Thursday, 7 December 2017

The RtS identifies that the proposed flood planning protection measures for the school that involves the construction of diversion walls around the site that will have an impact on flood levels around the site. The impact has been estimated as:

In order to address the above concerns, additional flood modelling has been undertaken by Northrop. Three meetings have been held with the City of Sydney Council to discuss the outcomes and to reach an agreed solution. We understand that City of Sydney Council are in support of the proposed solution.

FIGURE C2

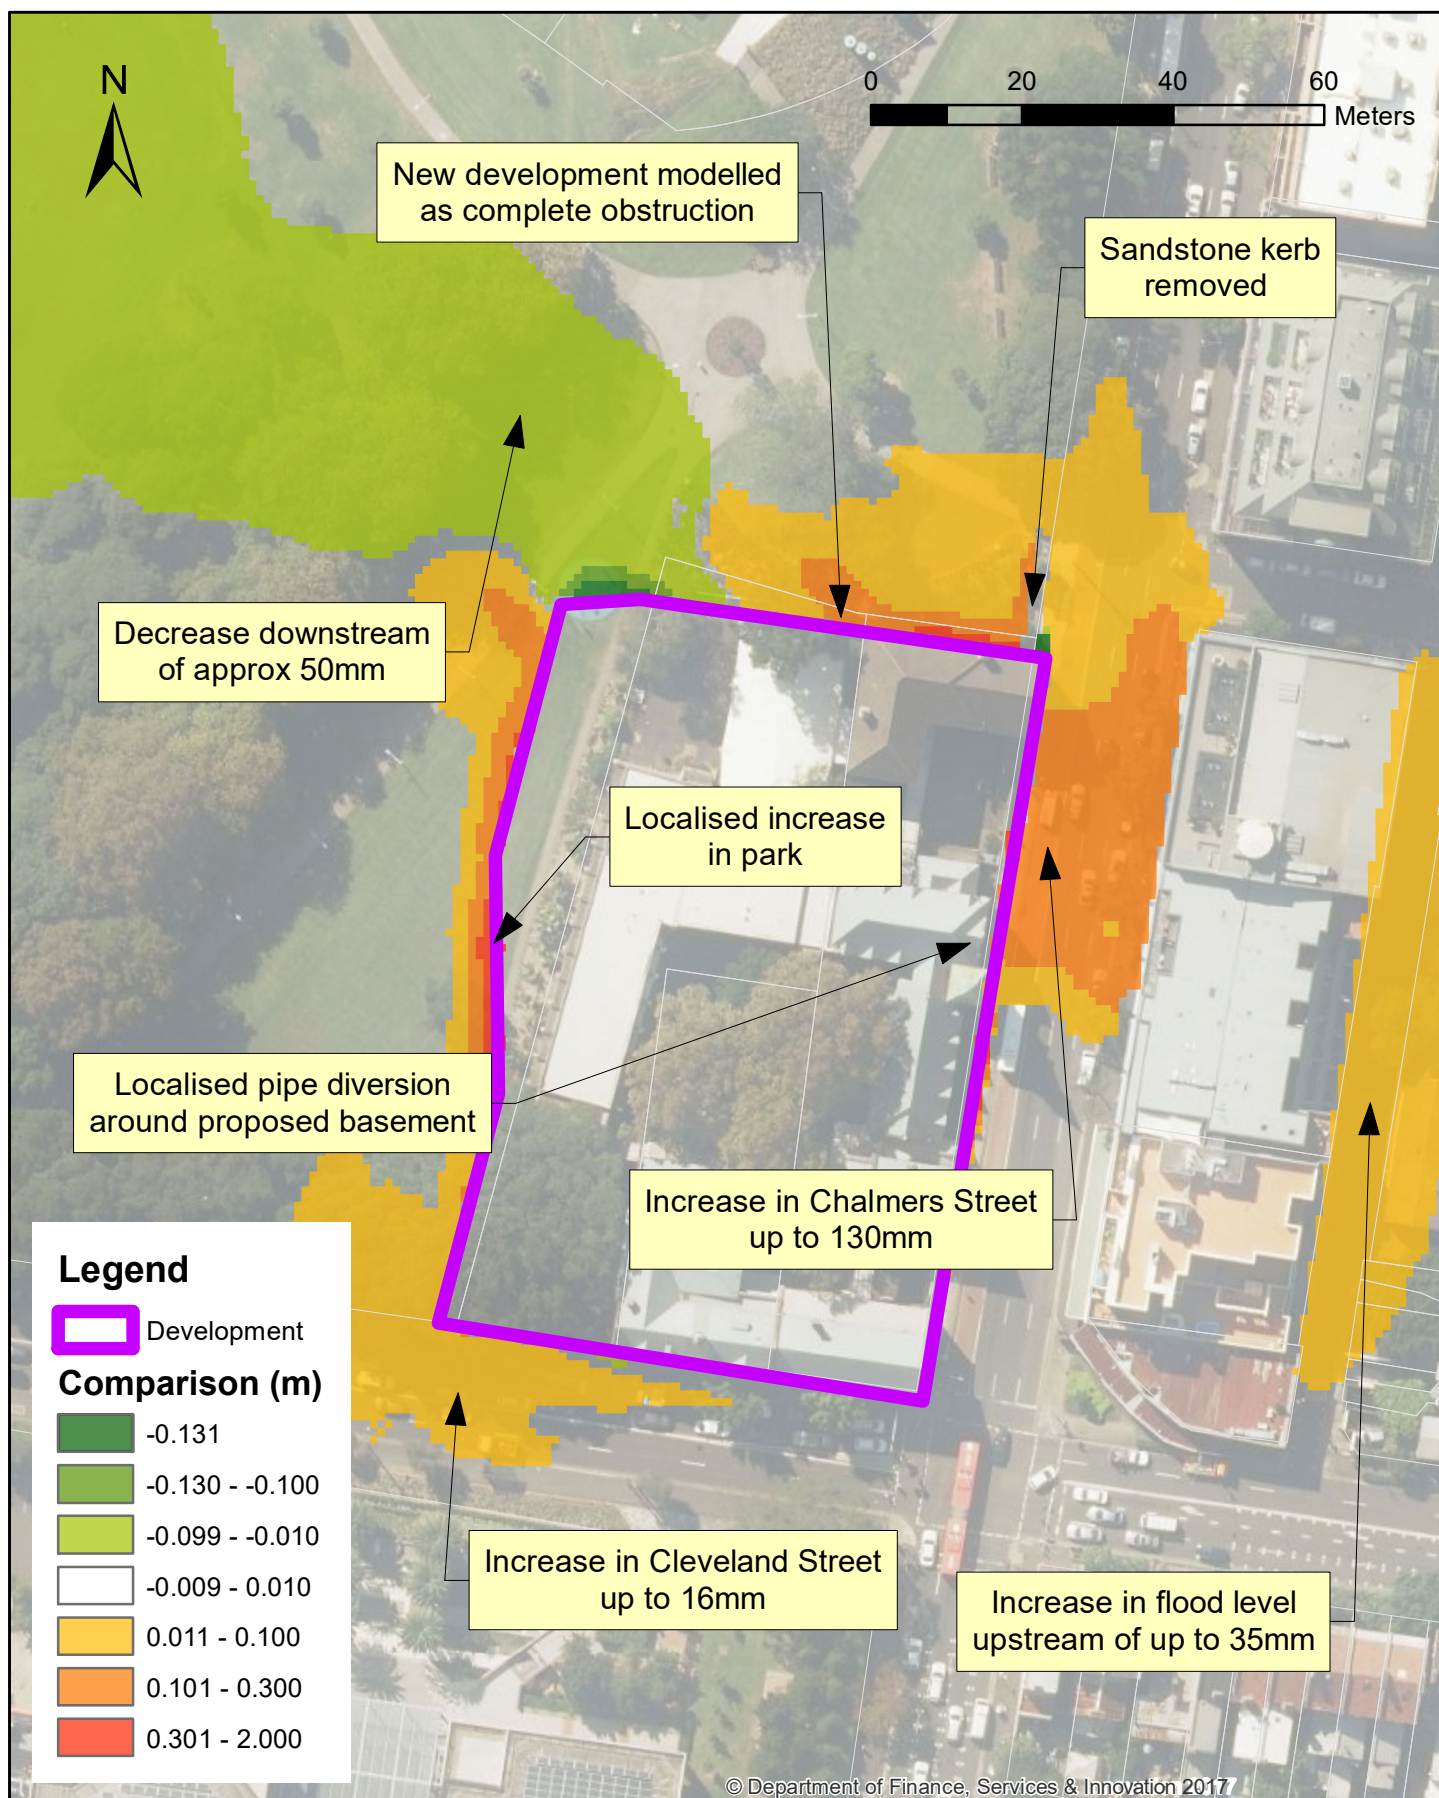
- raising of flood levels along the Chalmers Street frontage by up to 600mm,

- raising of flood levels by 85mm in Pembroke Street, and the

- raising of flood levels in Prince Alfred Park by 400mm in the 1% AEP storm event.

The result of this new modelling confirms that the increase in 100-year ARI flood level in Chalmers Street is 130mm only as opposed to the previously noted 600mm.

In order to mitigate the flooding on Chalmers Street it is proposed to remove the sandstone plinth to the north of Building 3 (the northern most heritage building as identified on the attached drawings) up to the current pathway. This will result in a flood level approximately 20mm below the floor level of the most affected property to the east of Chalmers Street (184 Chalmers Street).

With the removal of the sandstone plinth as identified above the flood levels are raised in Pembroke Street by 35mm. City of Sydney (Peter Garland) noted that significant flooding was a pre existing condition and not due to the new development of the Inner Sydney high school, therefore it is assumed that for the purposes of the Inner Sydney high school, this increase was acceptable.

With the removal of the sandstone plinth as identified above and more detailed survey data the flood levels lowered by 50mm.
